From: Holland, Gargi - Communities <Gargi.Holland@Oxfordshire.gov.uk>
Sent: 24 September 2020 09:26
To: Bob Neville <Bob.Neville@cherwell-dc.gov.uk>
Cc: Planning <Planning@Cherwell-DC.gov.uk>; Cllr Hannah Banfield <Hannah.Banfield@Oxfordshire.gov.uk>
Subject: RE: 20/02087/O56- Leisure Interiors 2000, 47F Broad Street, Banbury, OX16 5BT

Oxfordshire County Council, as the Local Highways Authority, hereby notify the District Planning Authority that they **object** to the granting of planning permission.

PROPOSED GROUND FLOOR PLAN
scale 1:50

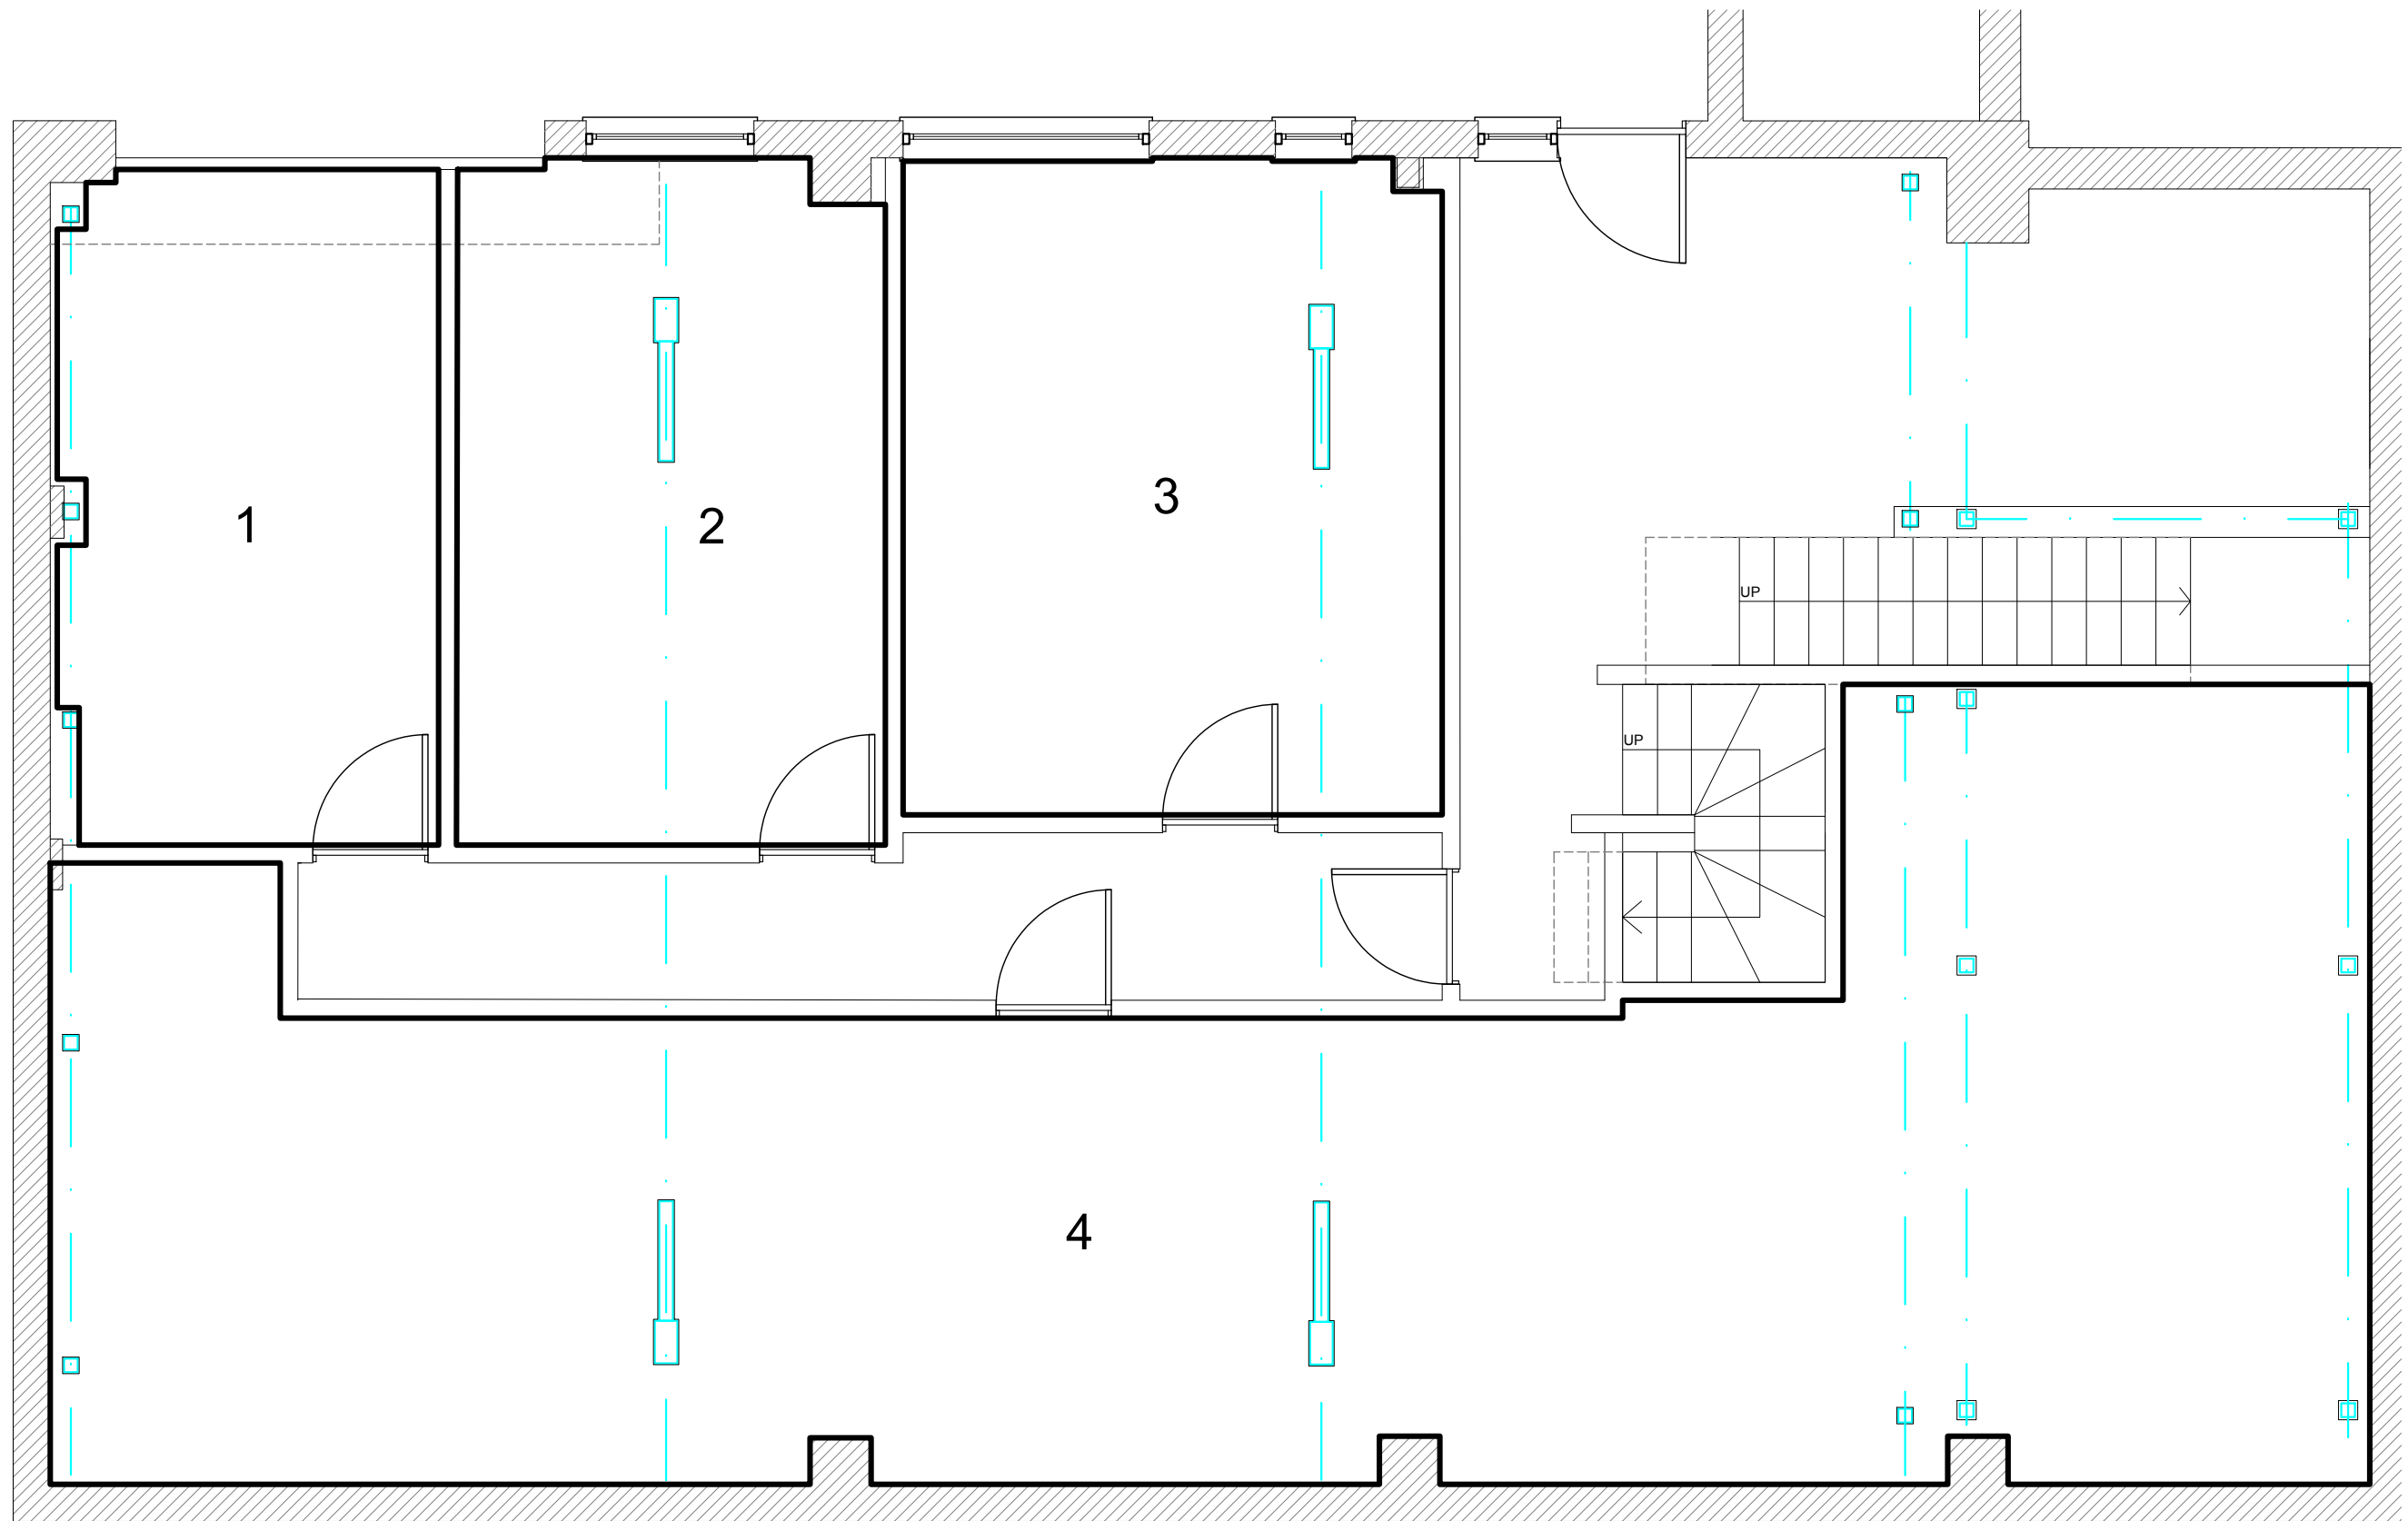
Most importantly as it is essentially a case of car free development, their Transport Statement says parking will be reserved for visitors, there is no mention of cycle parking facilities.
As it is essentially a car-free development, the minimum cycle parking standards must be met.

As the minimum cycle parking standards are not met, the proposal is likely to have any adverse impact upon the local highway network from a traffic and safety point of view, therefore I offer objection.
